2 October 2020
Our Ref: 20618A.25PS_RTS letter

RE: SSD-9483 UPGRADES TO CHATSWOOD PUBLIC SCHOOL AND CHATSWOOD HIGH SCHOOL

1 INTERFACE OF BUILDING P1 AND PRIVATE PROPERTY - SECTION AA  
SCALE 1:100

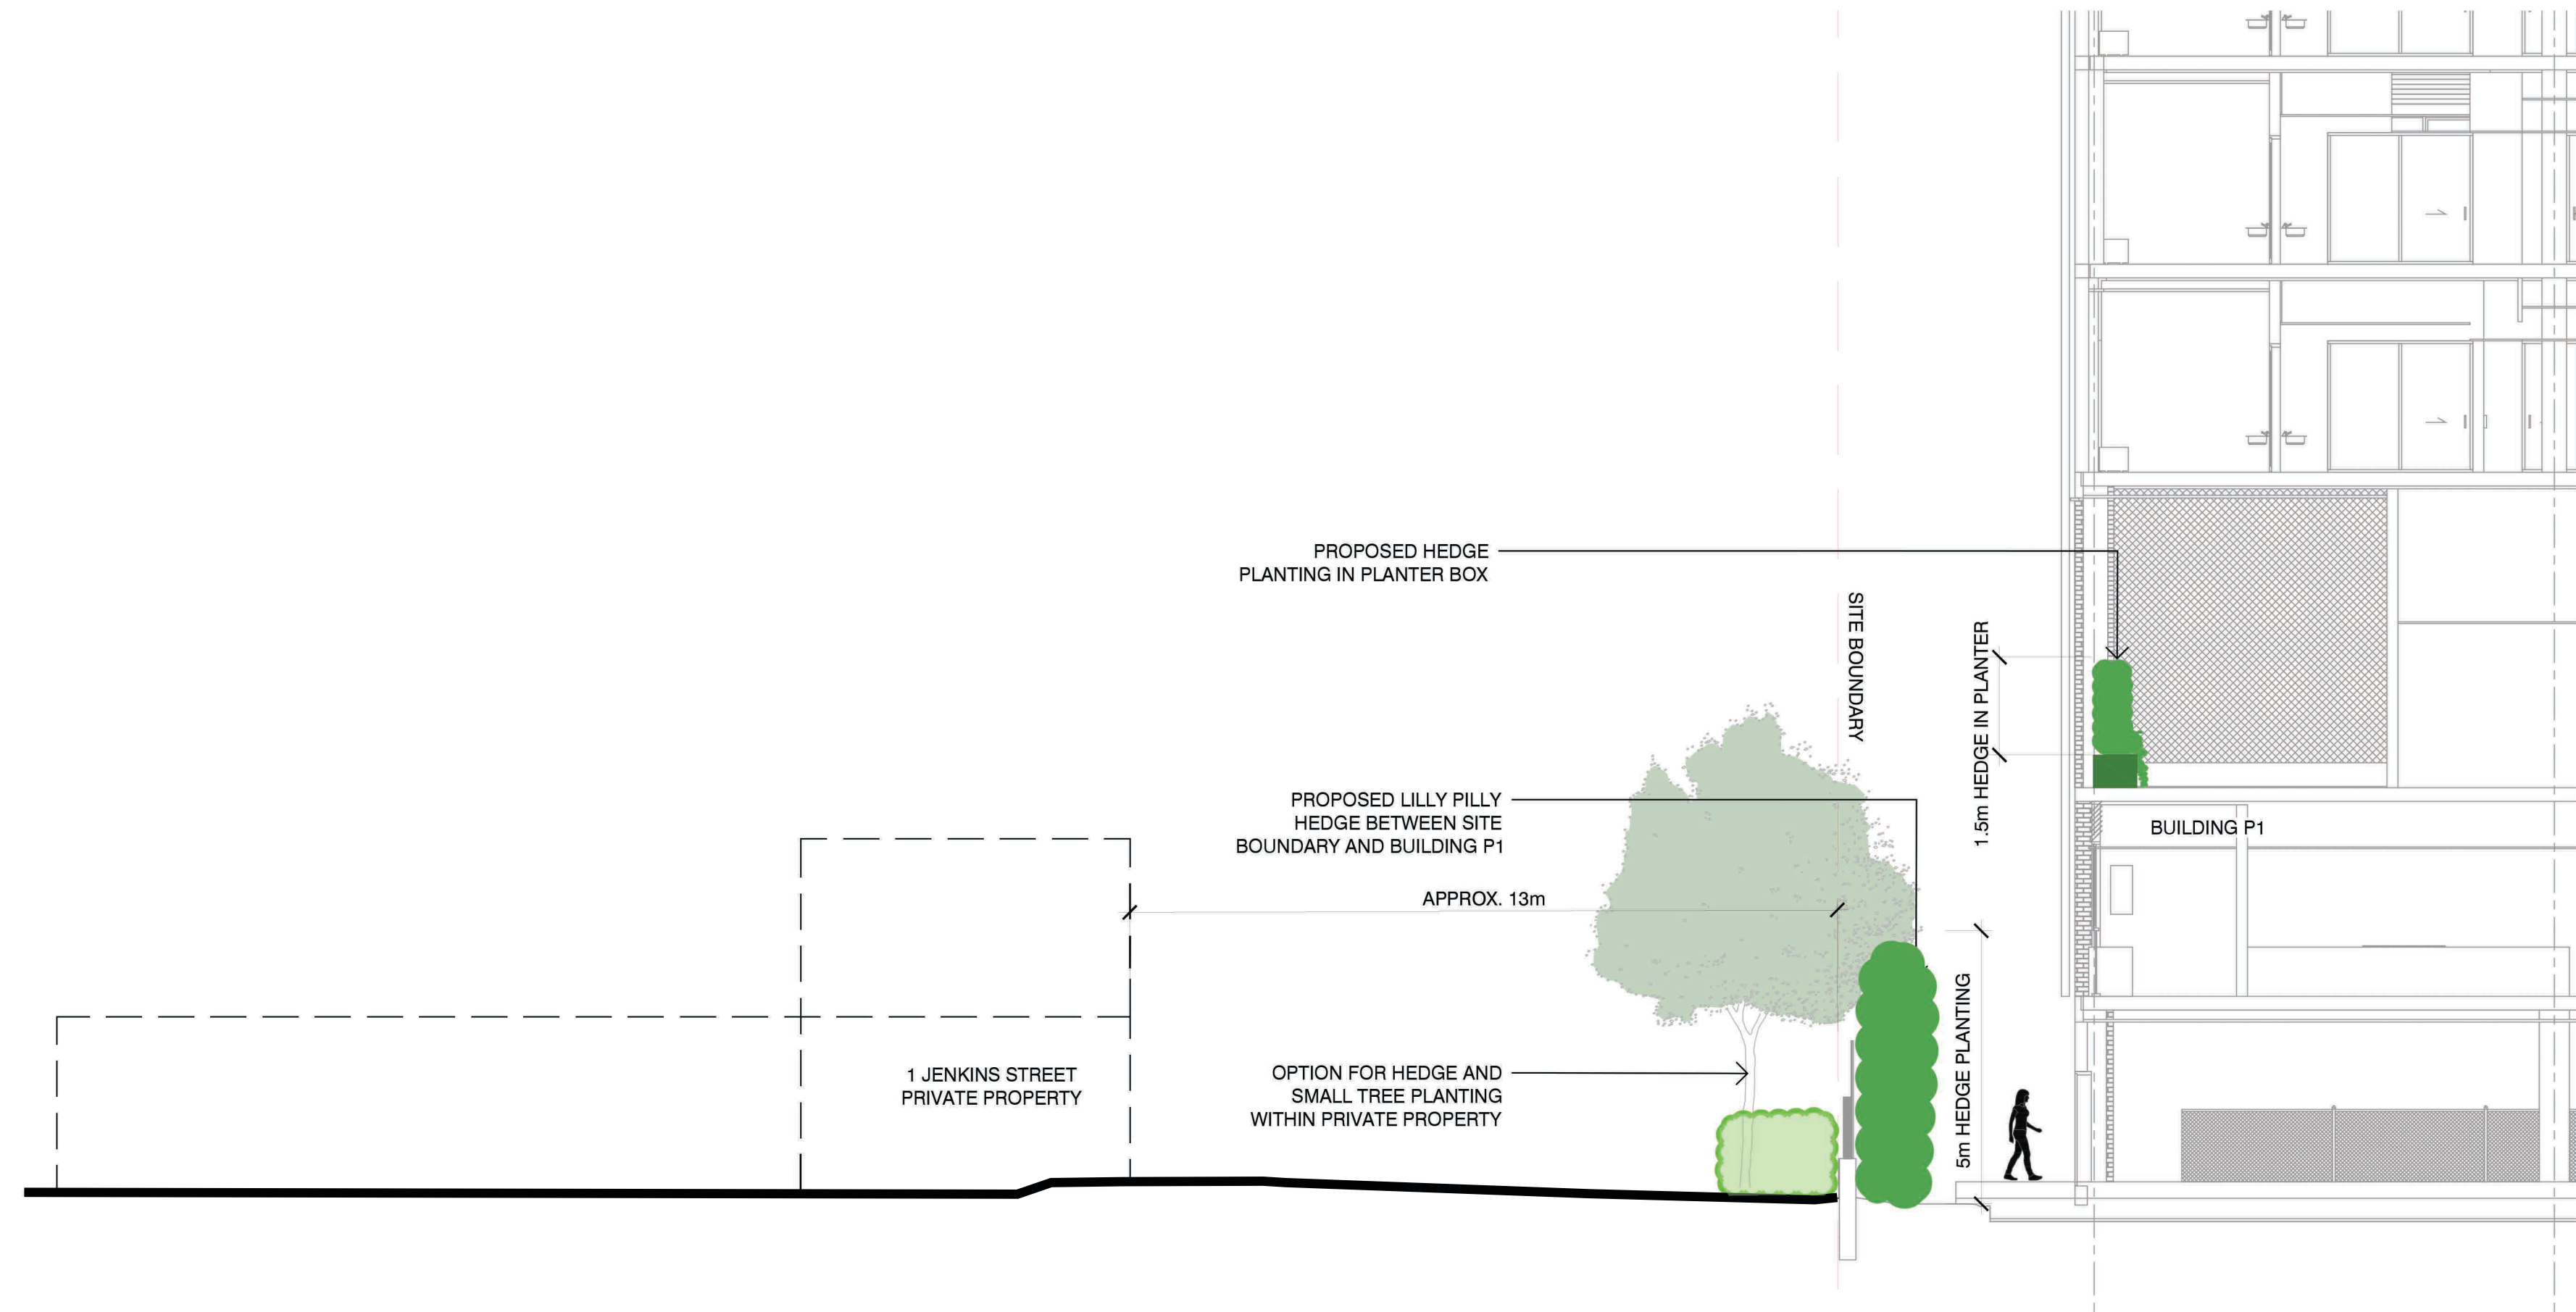
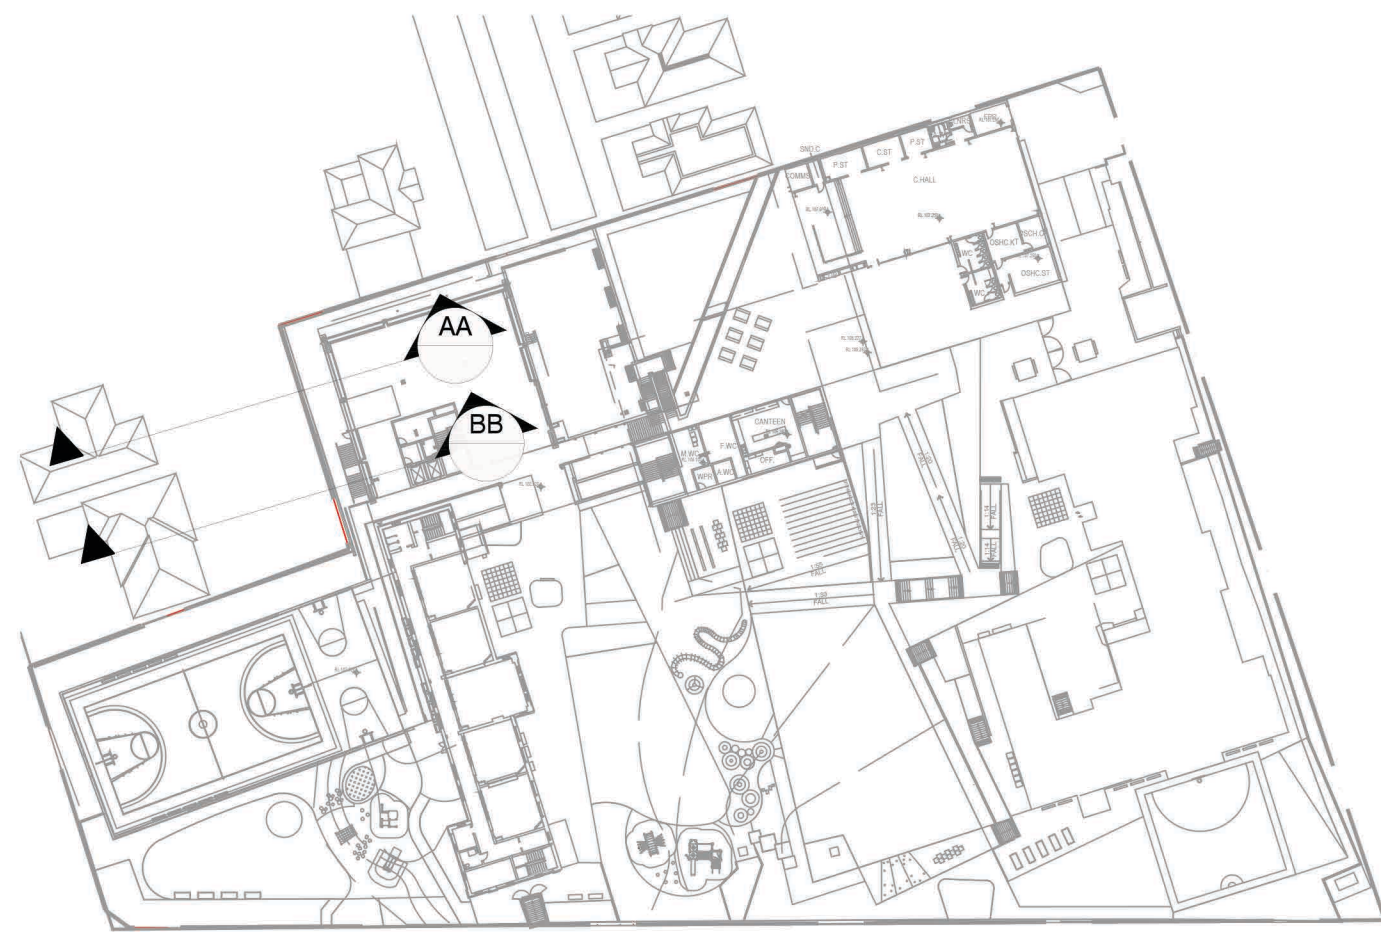
- Amenity impacts of the building on the low scale dwellings at No. 1 and No. 3 Jenkins Street and 2 James Street; and
- Excessive height for this part of the site given wall height, setbacks, shared boundaries, topography of the site and topography of adjoining sites.

Landscaping provided within the COLA and at ground floor will provide additional buffering of view lines and reduce perceived bulk and scale from the built form (**Attachment 12**), including hedge planters at the COLA and additional hedge planting proposed on the lower ground floor level (**Figure 6**).
